BARNSLEY
Metropolitan Borough Council

My Ref: 2021/1449 (2020/0196)
Your Ref: As above
Date: 7 April 2022
Enquiries to: Helen Willows
Direct Dial: 01226 772642
E-Mail: helenwillows@barnsley.gov.uk

**Discharge of conditions 3 (external materials), 4 (drainage), 5 (trees), 6 (hard and soft landscaping), 9 (broadband), 12 (construction details of the streets proposed for highway adoption) and 14 (EVCs) of planning permission 2020/0196 – Residential development of 9no bungalows and associated works including access road, gardens and garages.
Land off Birk Avenue, Kendray, Barnsley, S70 3AH.**

CLIENT: KIRSOPP BUILDING CONTRACTORS Ltd.
PROJECT: PROPOSED DEVELOPMENT
OFF BIRK AVENUE
KENDRAY, BARNSLEY
TITLE: HIGHWAYS G.A.

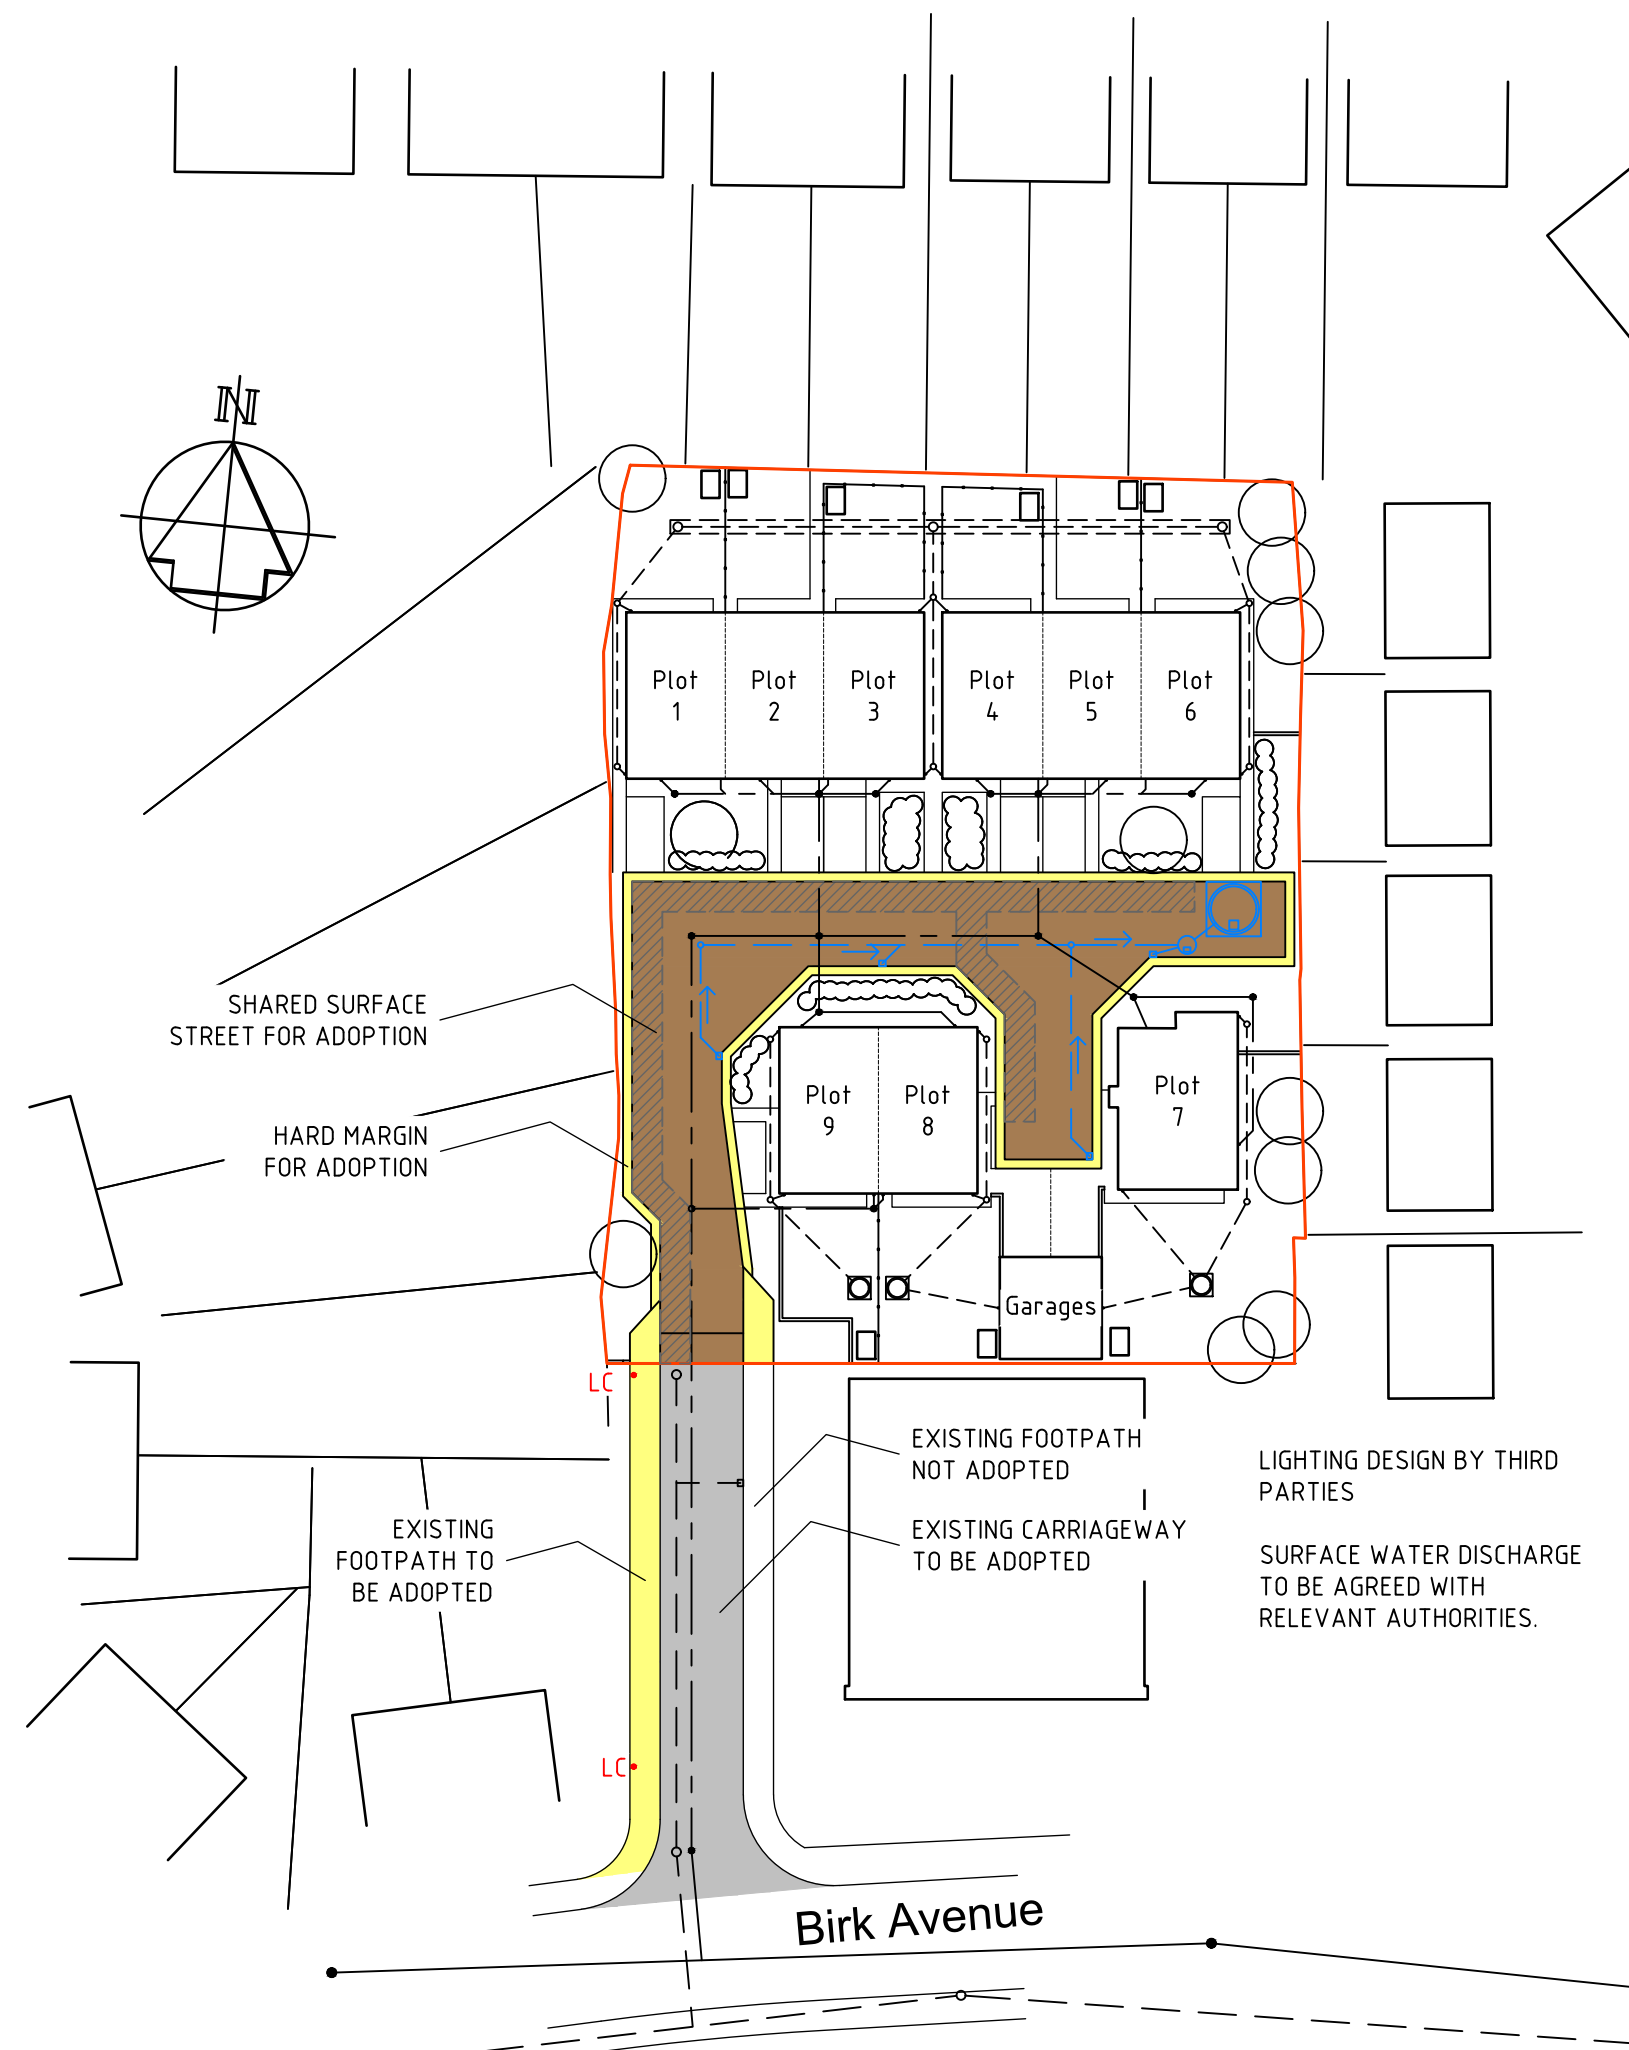
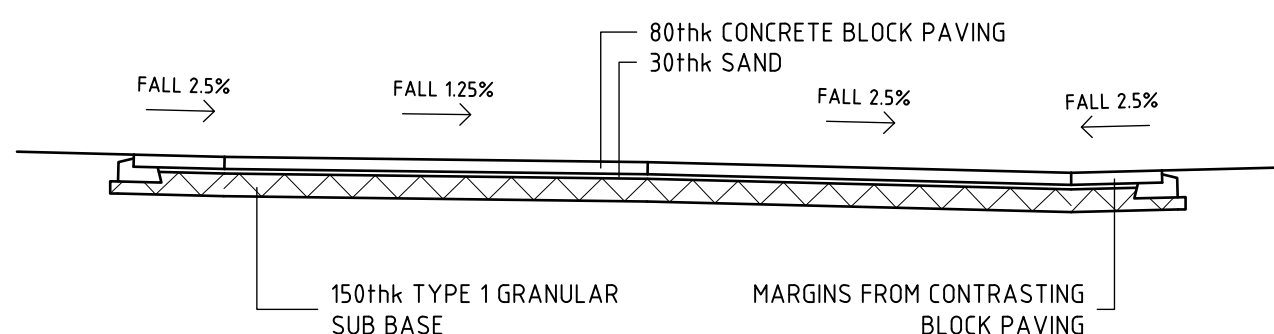
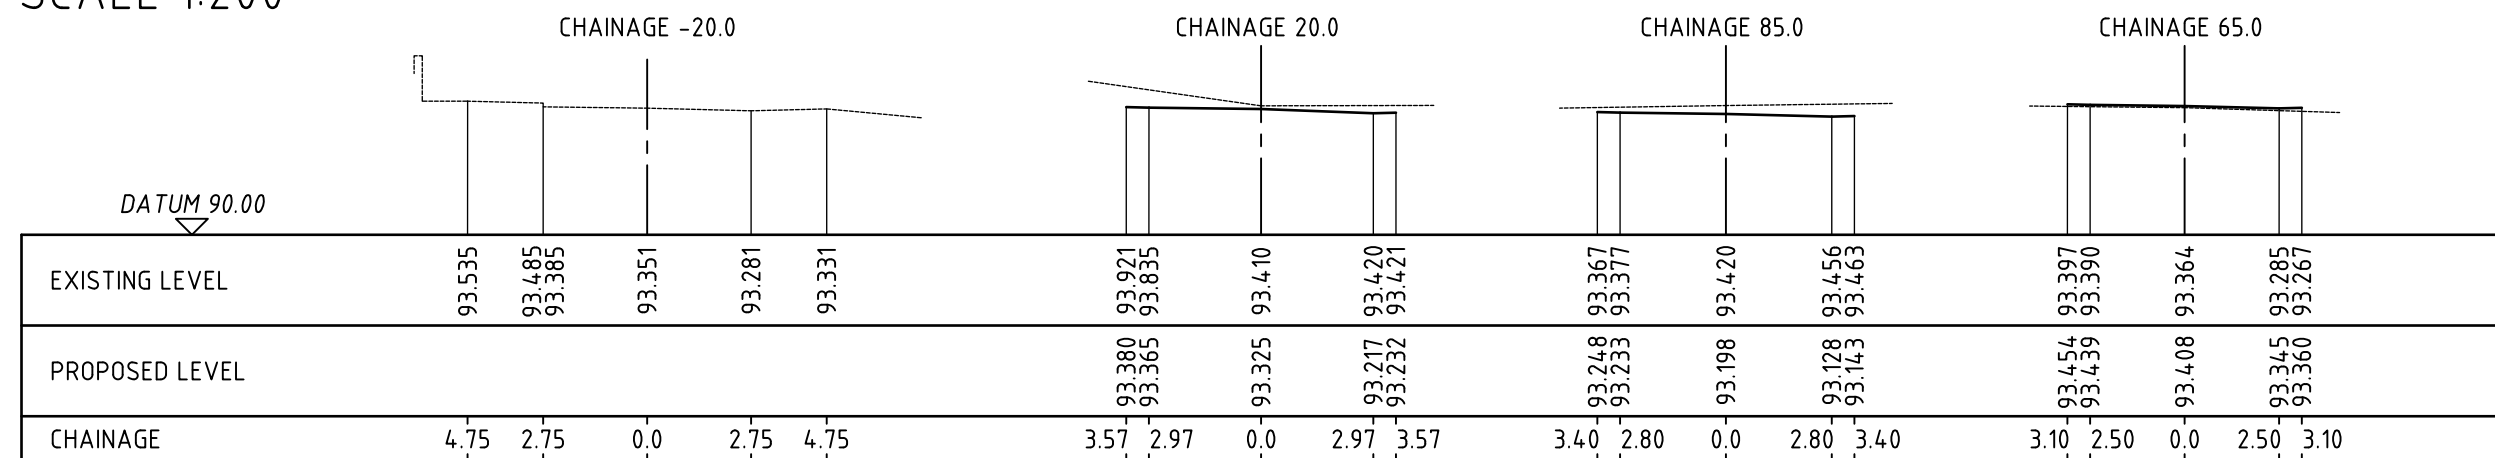
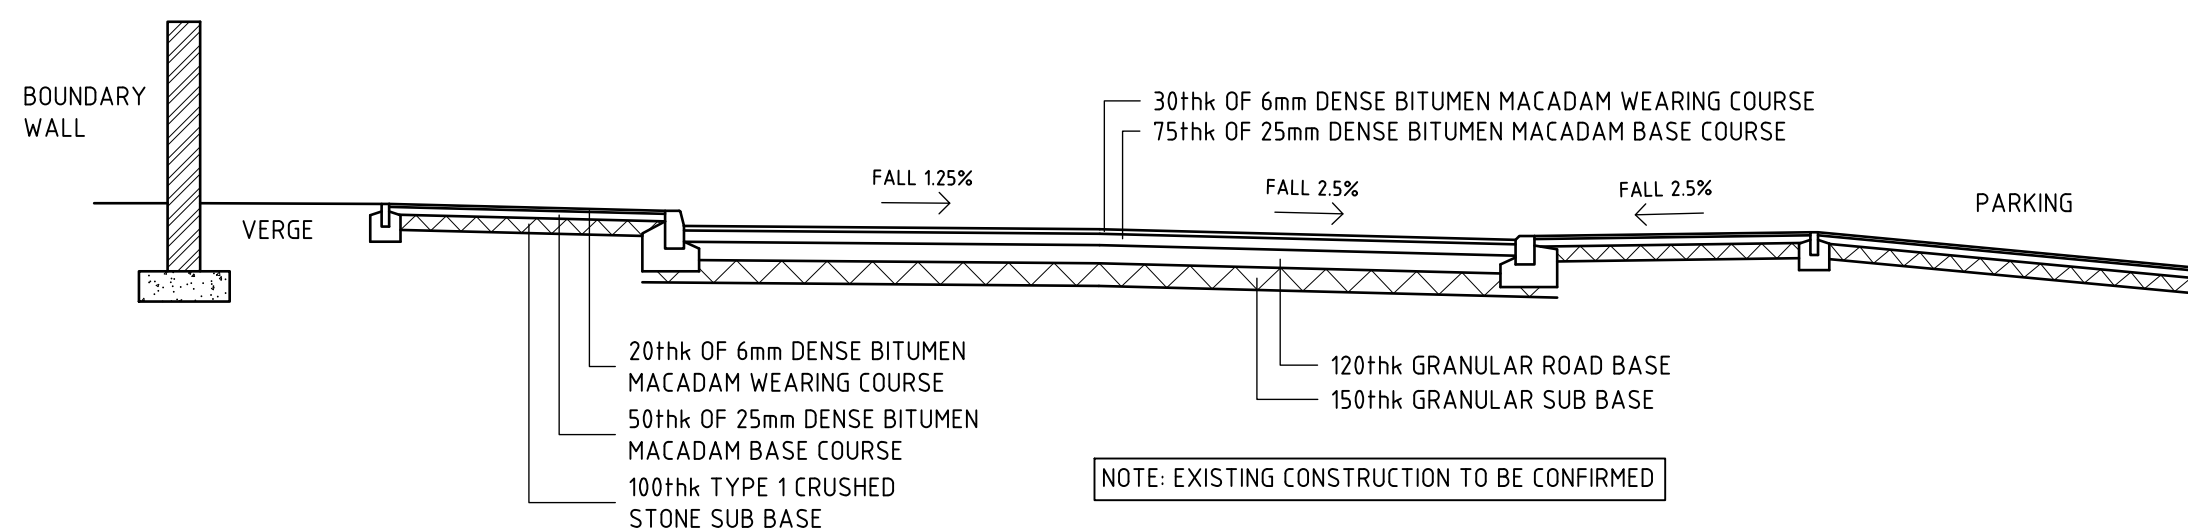
Details of the planning permission that were required by **condition 12 (construction details of the streets proposed for highway adoption) may NOT be discharged**. I have previously advised you that I don't have sufficient information to discharge this application and forwarded advice from Highways Development Control which sets out what information you will need to submit. I have not received any further information.
